From: maxine north [REDACTED]
Sent: 14 June 2019 11:38
To: Planning
Subject: Objection to Planning application AL/42/19/PL

Objections to planning application AL/42/19/PL against The Adoption Arun Local Plan

Proposed Elevations

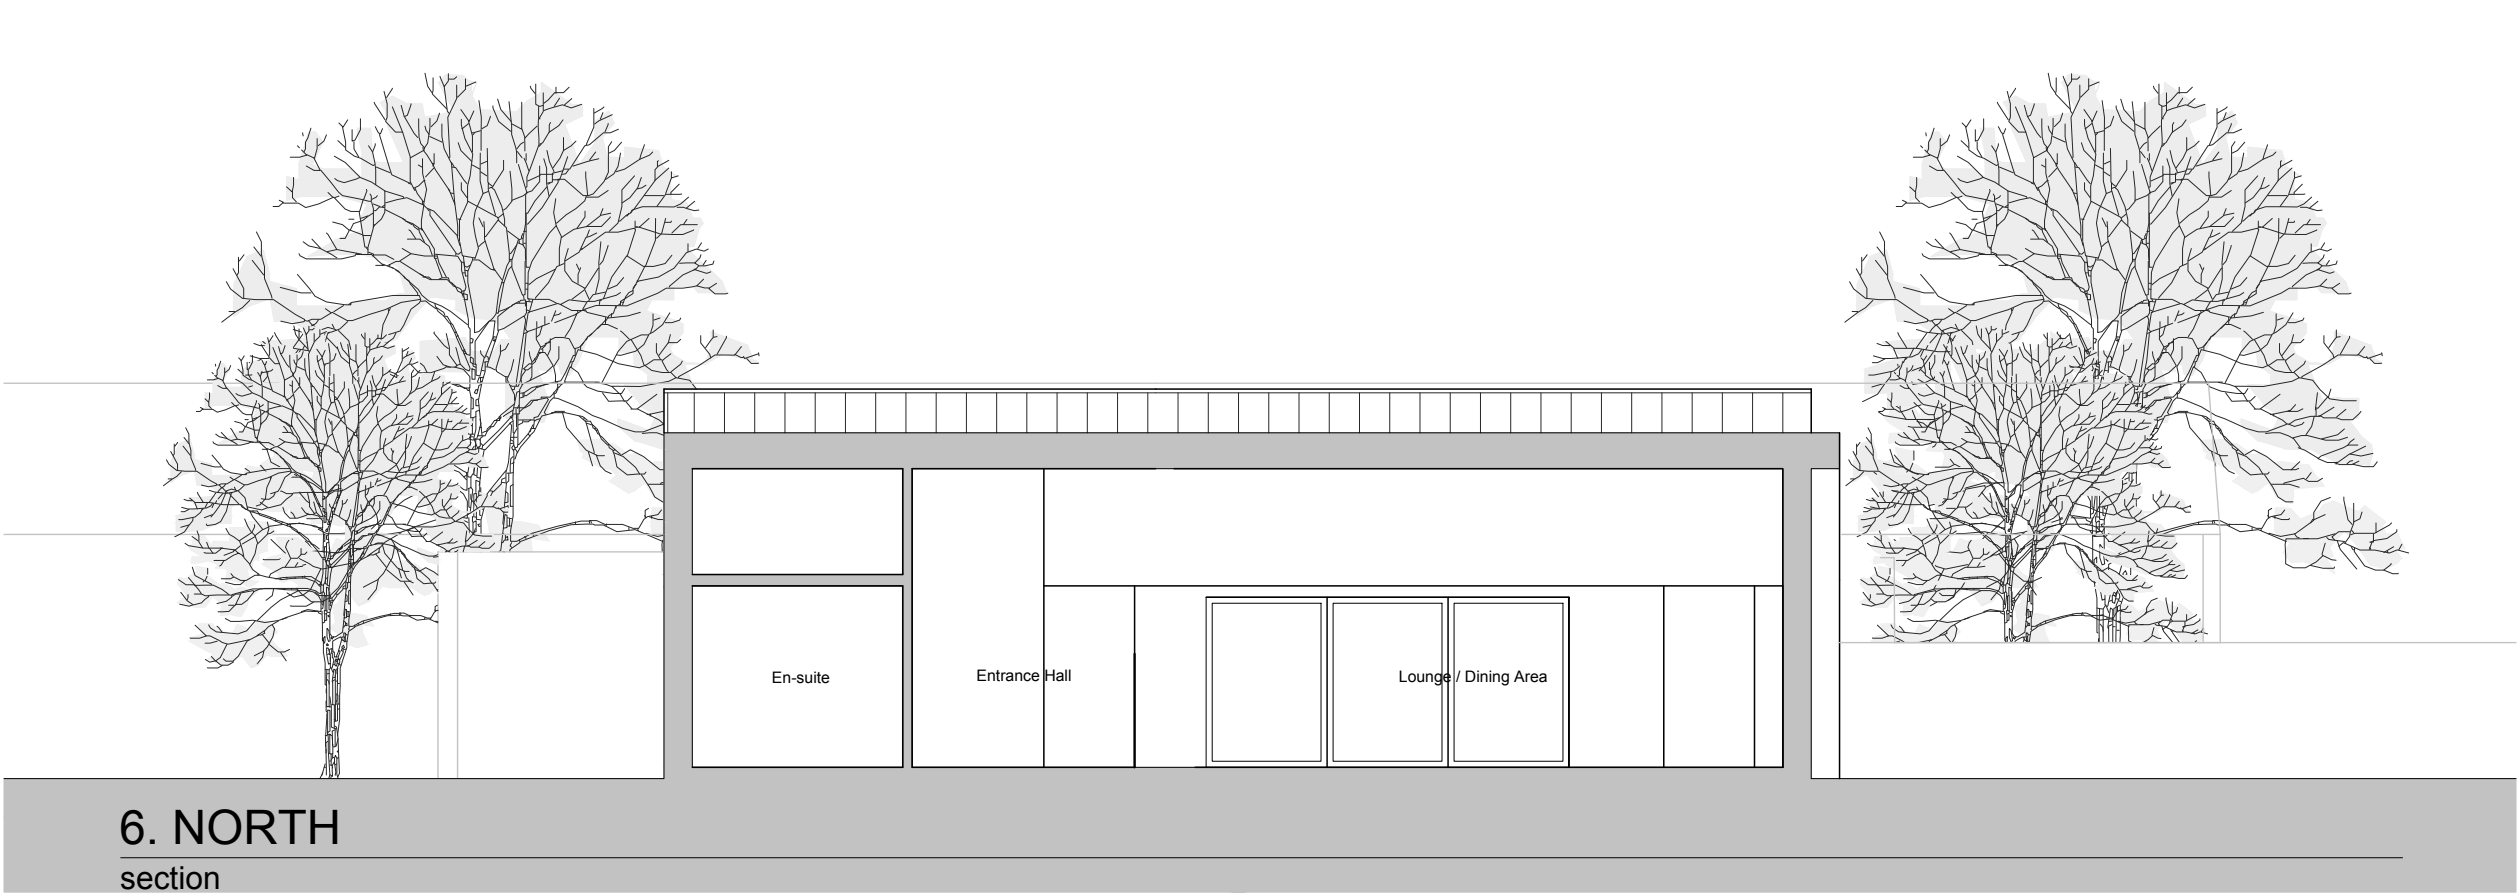
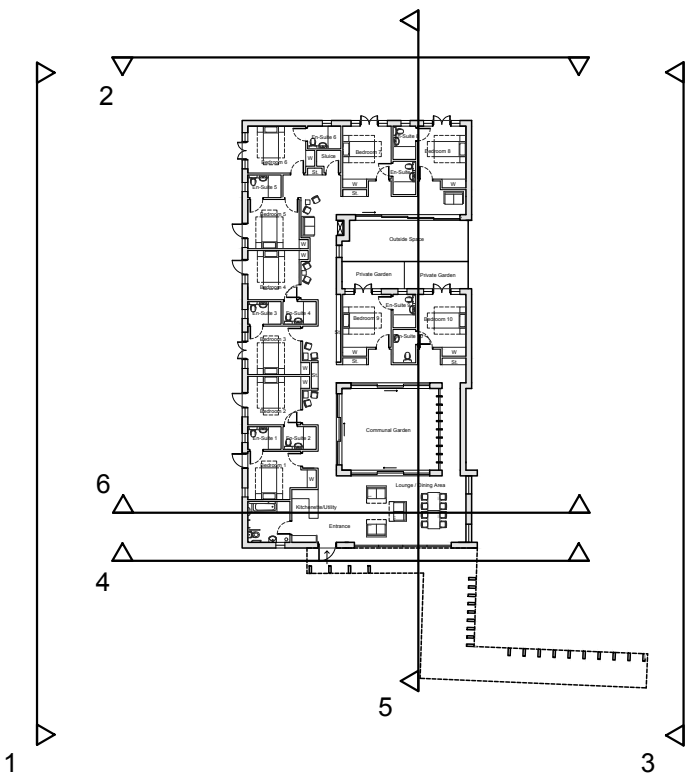
The proposed materials have no link to the surrounding properties, especially the proposed red zinc roofing. The nearby properties have roofs mainly constructed with clay tiles or thatch. The proposed plans do not even compliment the local farm buildings. The Aldingbourne Parish is rural in character, the proposed Dementia Unit does not reflect the nature of this.

The proposal will remove the outlook to the rear of Wyncote with its 5.1m roofline which is 3.5m higher than the current boundary which in turn removes Wyncote's views of the Grade II listed Knighton Grange Cottage.
